From: Andrew Assinder [REDACTED]
Sent: 29 April 2021 14:13
To: Richard Sherman <Richard.Sherman@arun.gov.uk>; Planning <Planning@arun.gov.uk>
Cc: AA Home [REDACTED]
Subject: FP/58/21/HH Planning Application - Comments

Dear Sirs, FAO Arun Planning Department and Mr Richard Sherman

with regard to the above planning application, the following are our comments. Though we have very strong objections to the proposed balcony, we also propose acceptable alternatives in a spirit of constructiveness and without detriment to the rear extension and larger porch.

PROJECT Howard, No.45	DRAWING NO. 1475-P004	SCALE 1:100 @ A3	11	A
ADDRESS No.45 Crossbush Road Felpham	DRAWING TITLE Existing & Proposed First Floor Plans	DRAWN BY CRE8TIVE LINES - ROZ NOWAK		
ARUN DISTRICT COUNCIL FP/58/21/HH PO22 7LT		March 2021

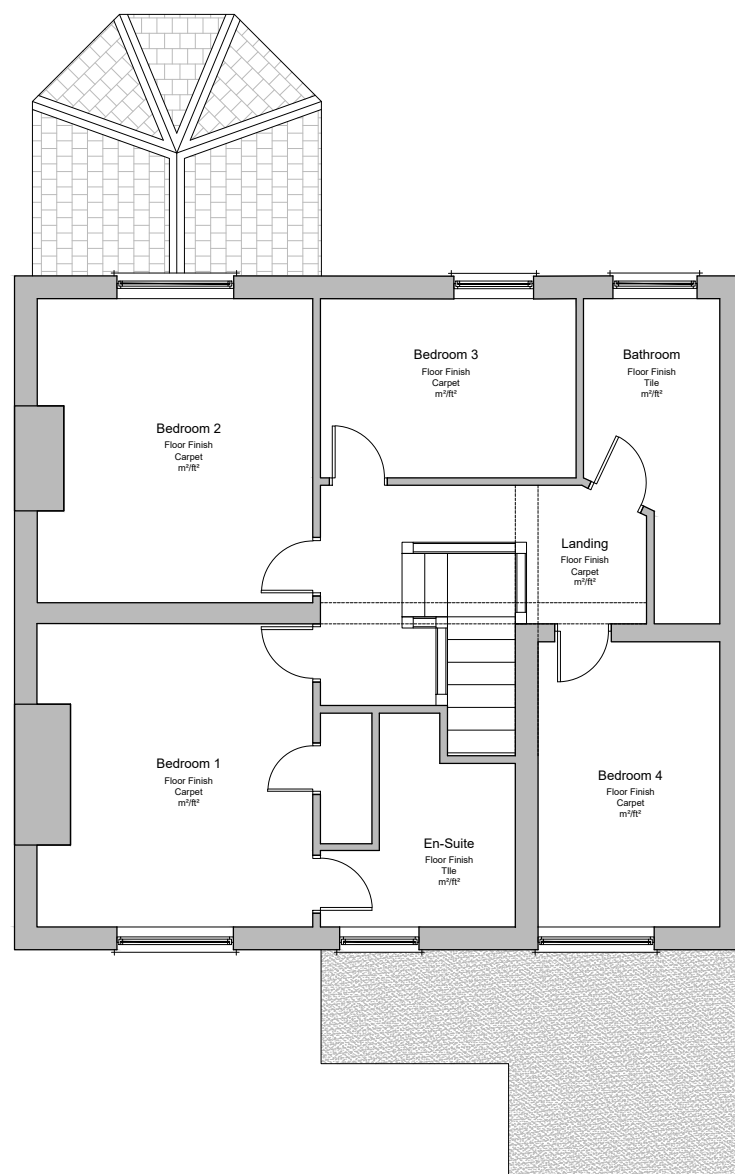
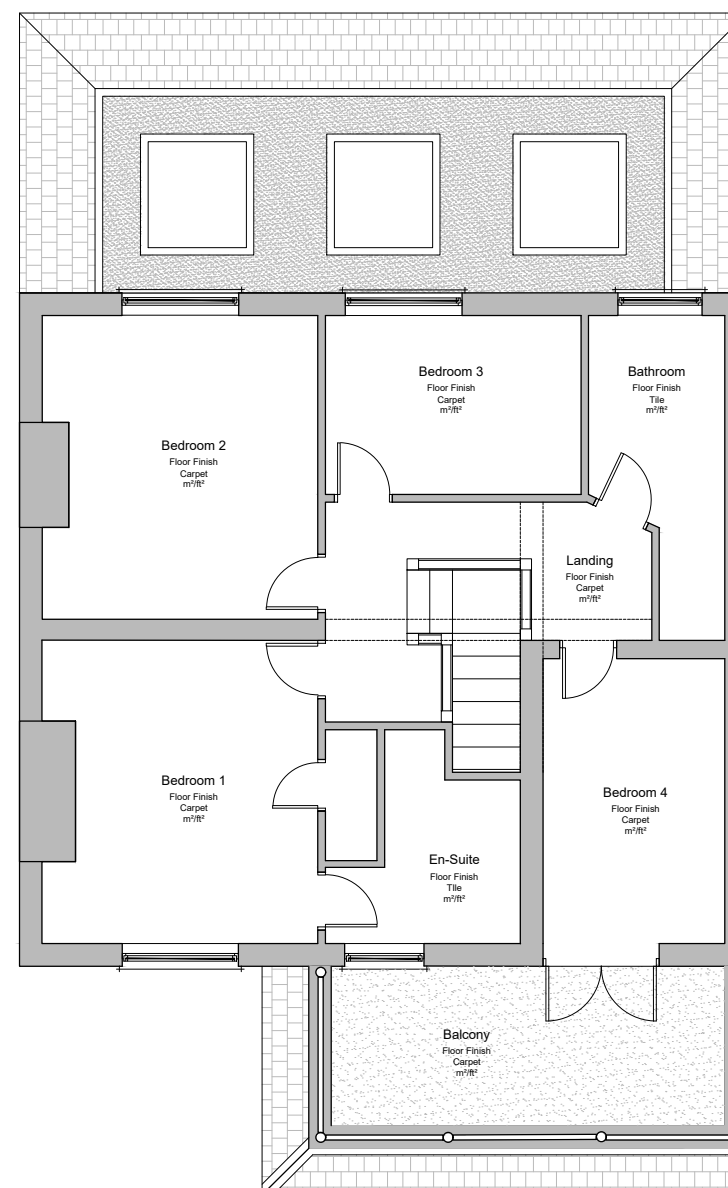
- the proposed front balcony would provide a first floor height viewing platform just over three metres distant towards no 47 spanning from the northeast to southeast directions, giving sight into the kitchen, cloakroom, bedroom and especially the full height landing feature window. These windows are all glazed with clear glass as since the house was built they have never been overlooked. The balcony structure and false roof would block the only remaining skylight into these west facing windows. Please refer to Fig 3 showing the balcony view point and our landing window sightline. It is hoped that the essence of the problem is evident in this figure. The balcony view to the southeast also becomes more intrusive than existing windows into the enclosed front garden, but this is a lesser concern.

-The east wall of no 45 is only 1,1m from the boundary, therefore the eastern false roof and screening as drawn will be less than 1,2m, and the false roof overhang will be less than 1,0m.

- The Drawing 1475-P004, First Floor plans, has omitted the crown tiled roof overhang to the east, which would show that it extends to under 1 m from the east boundary, significantly less than the 1,2m SEMCO policy requirements;
